Our ref: DOC19/1003487

Subject: EES comments on Environmental Impact Statement for Western Sydney University Bankstown City Campus – SSD-9831 – 74 Rickard Road and part 375 Chapel Road Bankstown

Subject: EES comments on Environmental Impact Statement for Western Sydney University Bankstown City Campus – SSD-9831 – 74 Rickard Road and part 375 Chapel Road Bankstown

DRAWING
Tree Removal Plan

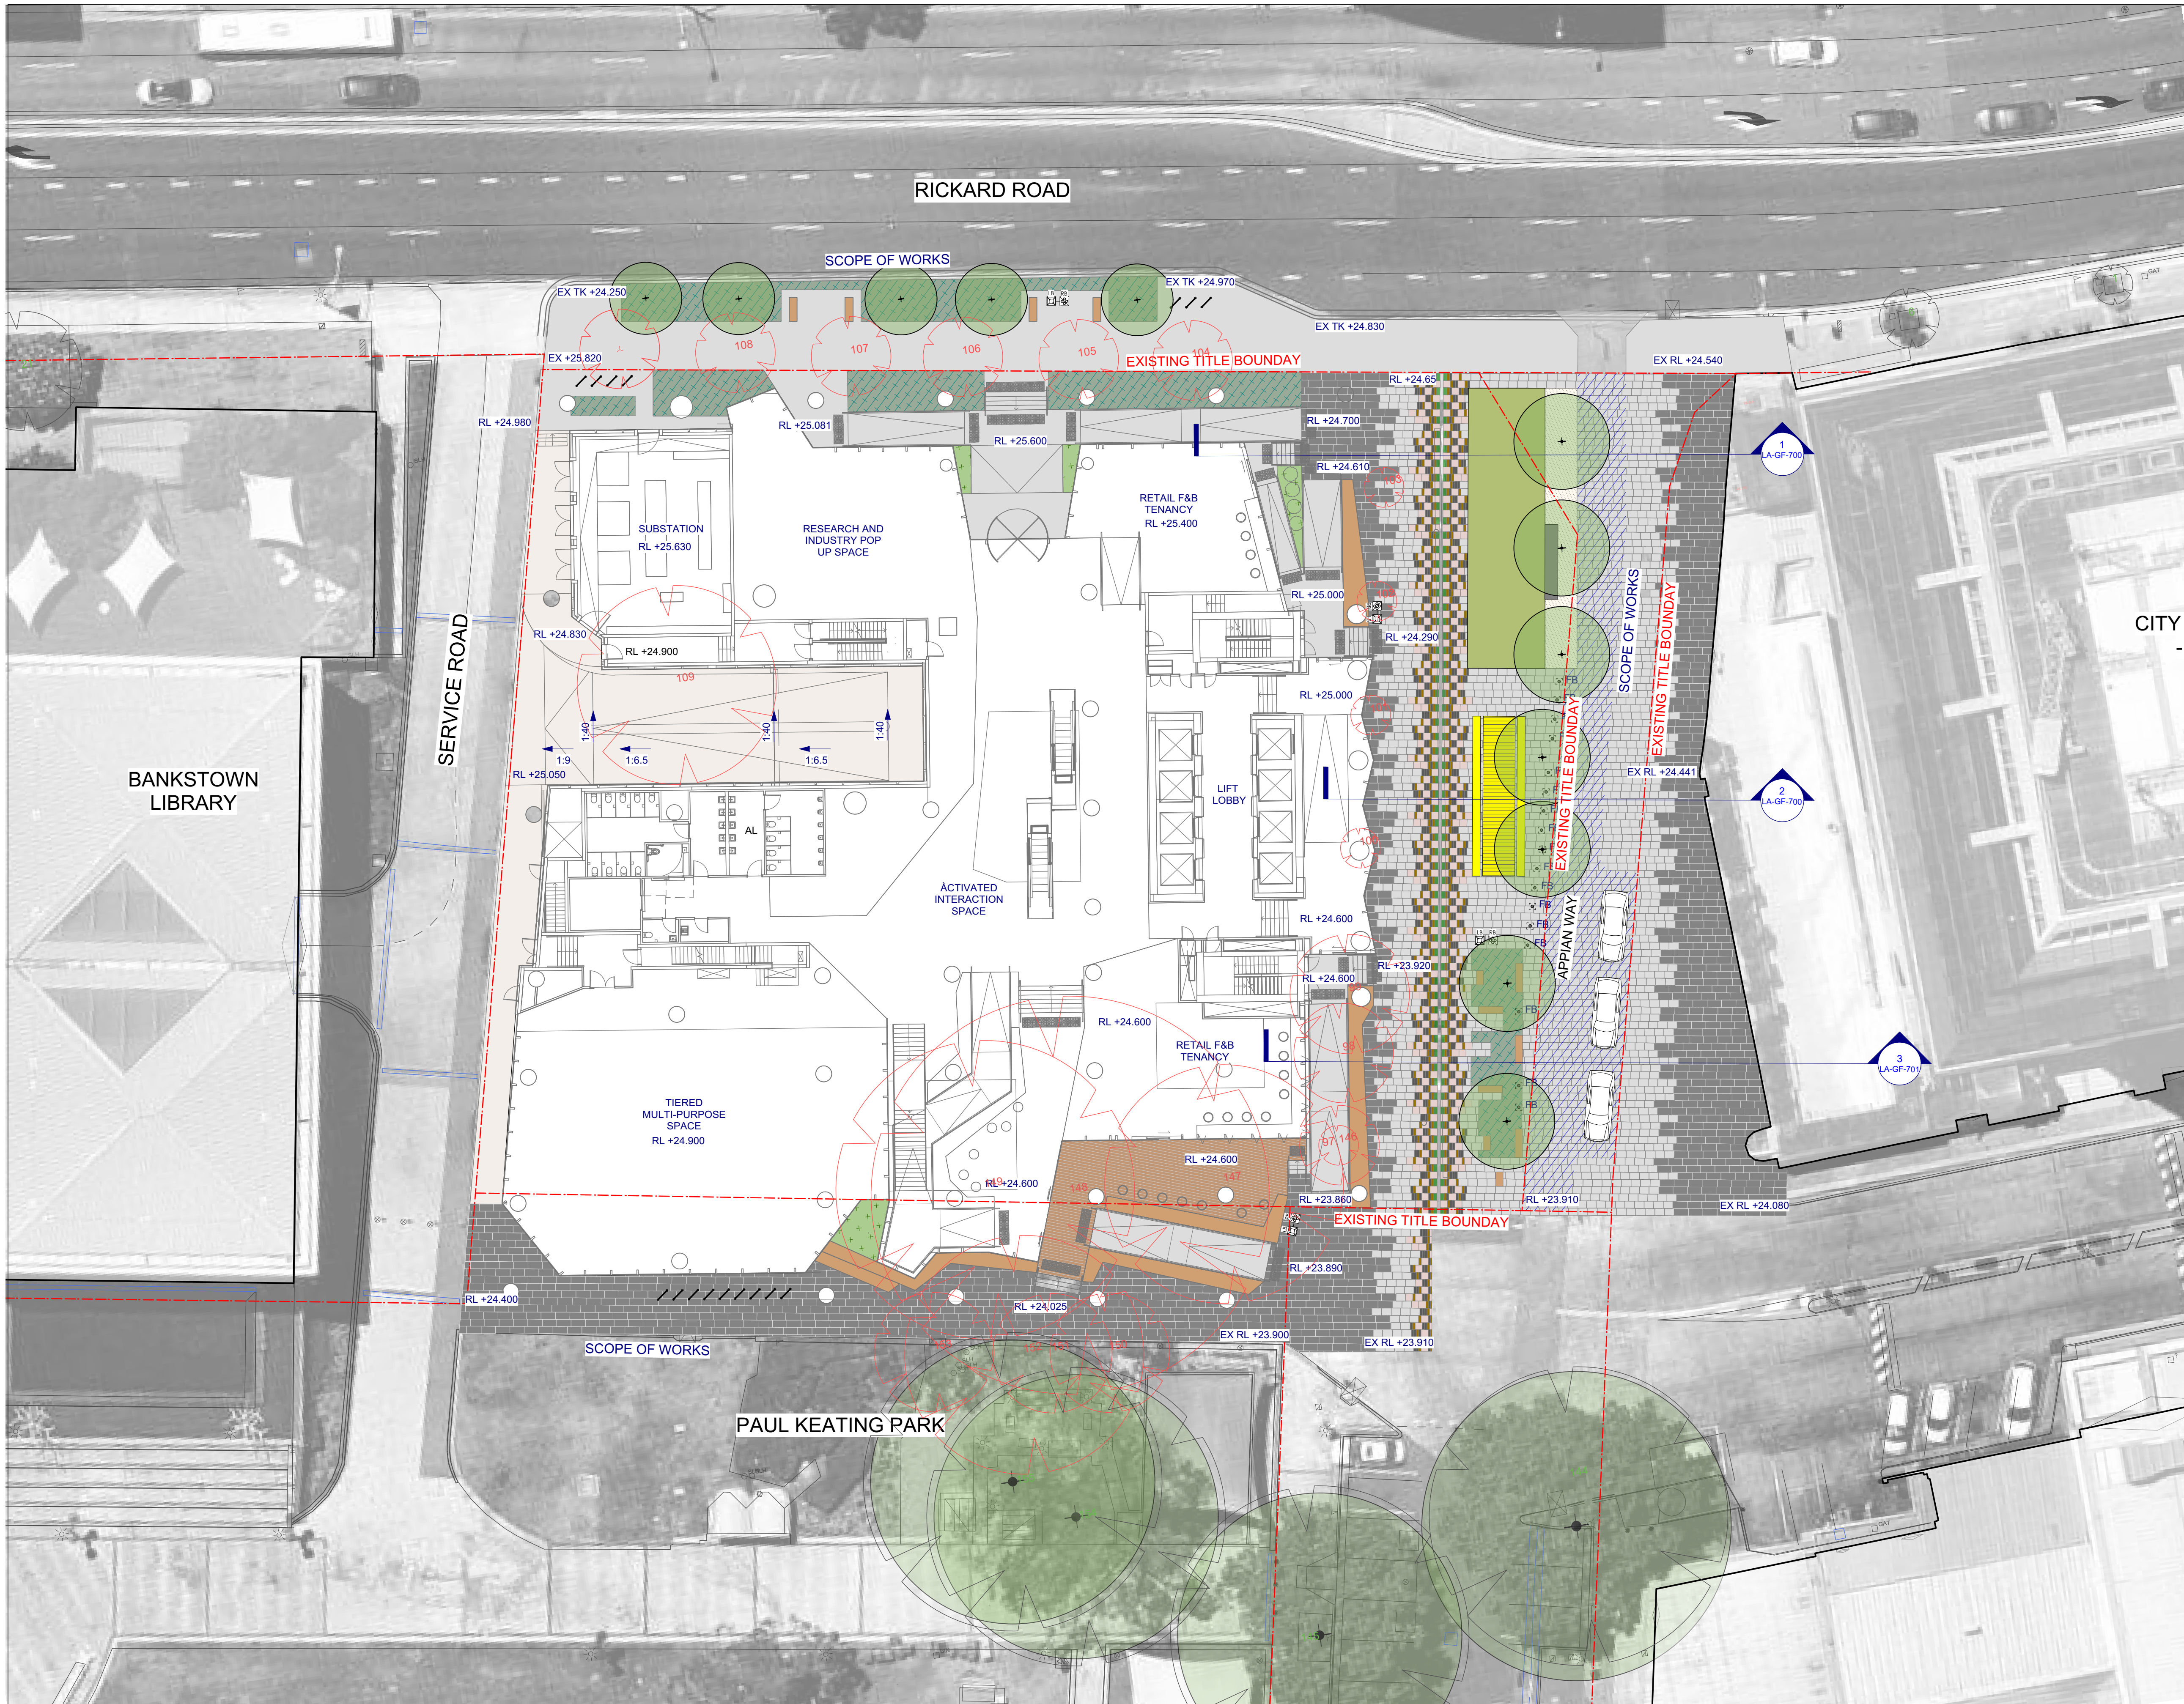
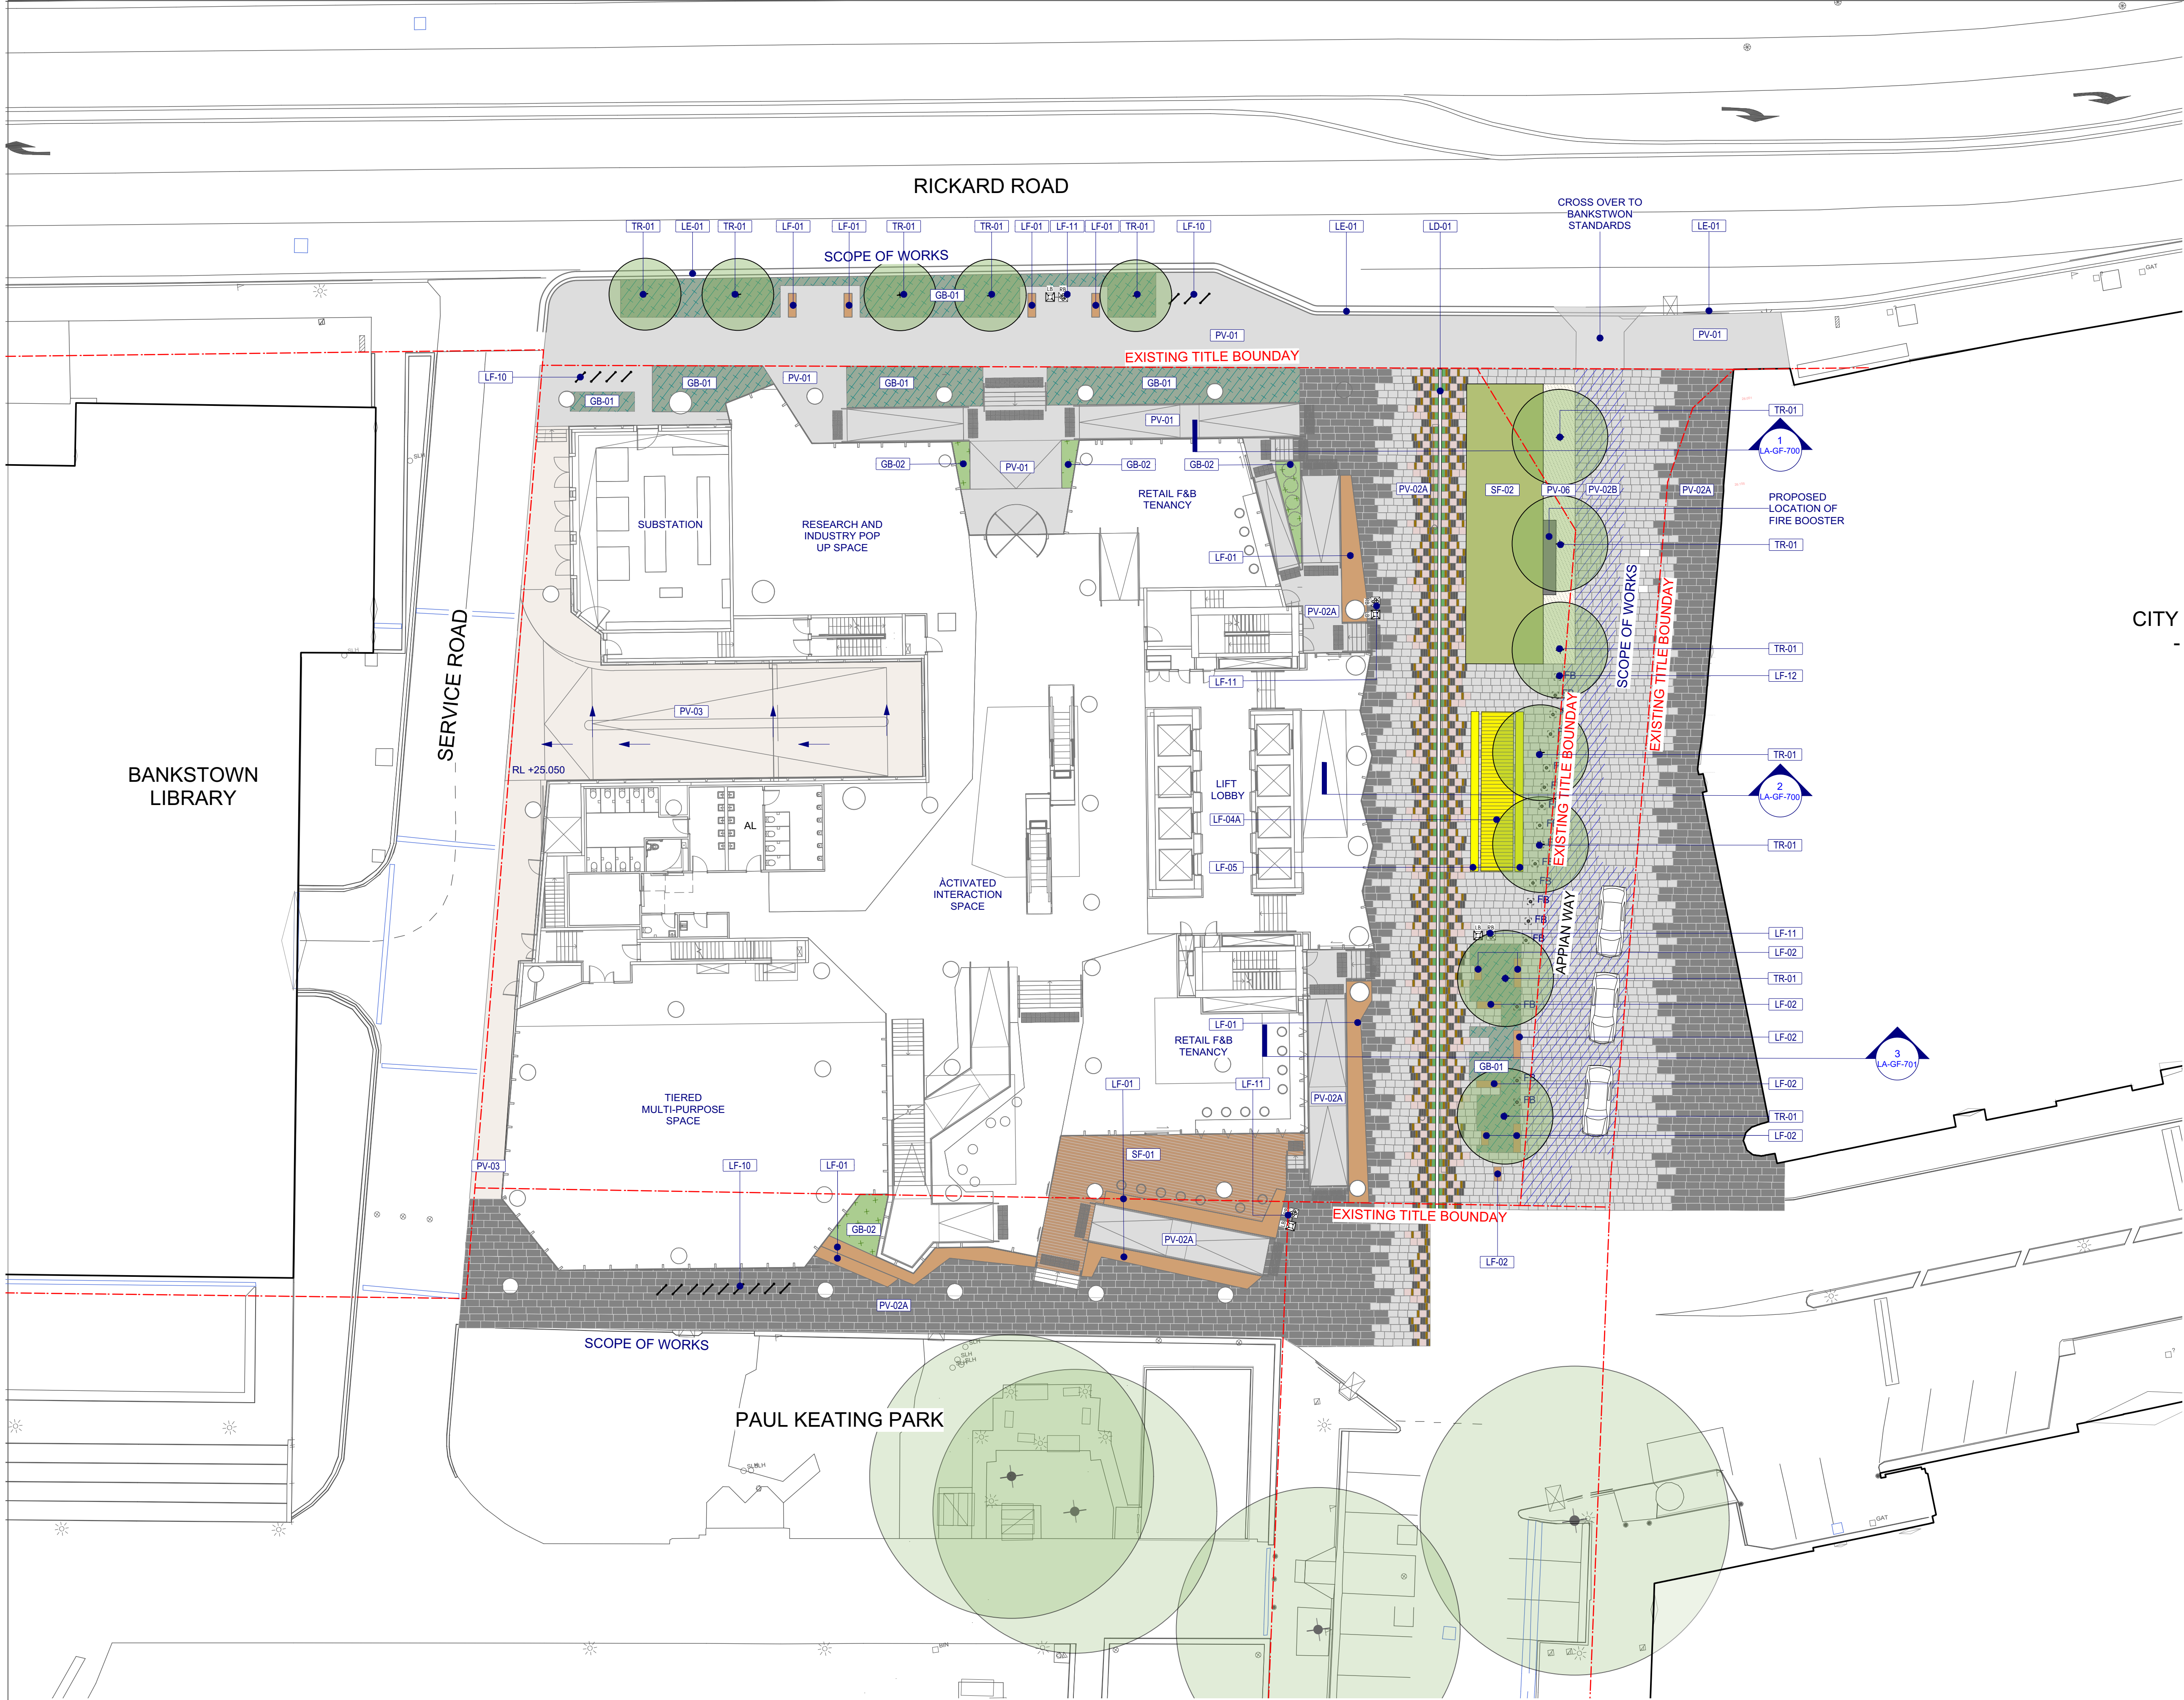
The number of trees proposed to be removed for this development appears to have increased, as the BDAR waiver request (dated 4 February 2019) indicated 17 trees were to be removed, whereas the EIS notes 23 existing trees will be removed on, or adjacent to the site (page 15). The RTS needs to:

- provide details on why the number of trees that are proposed to be removed has increased
- confirm the number of existing trees that are to be removed
- clarify whether the proponent proposes to replace the trees that are to be removed at ground level at a ratio of greater than 1:1.

1. Trees removed by the development shall be replaced at a ratio greater than 1:1 at ground level.
2. Sufficient area/space is provided on site to allow the trees to grow to maturity.
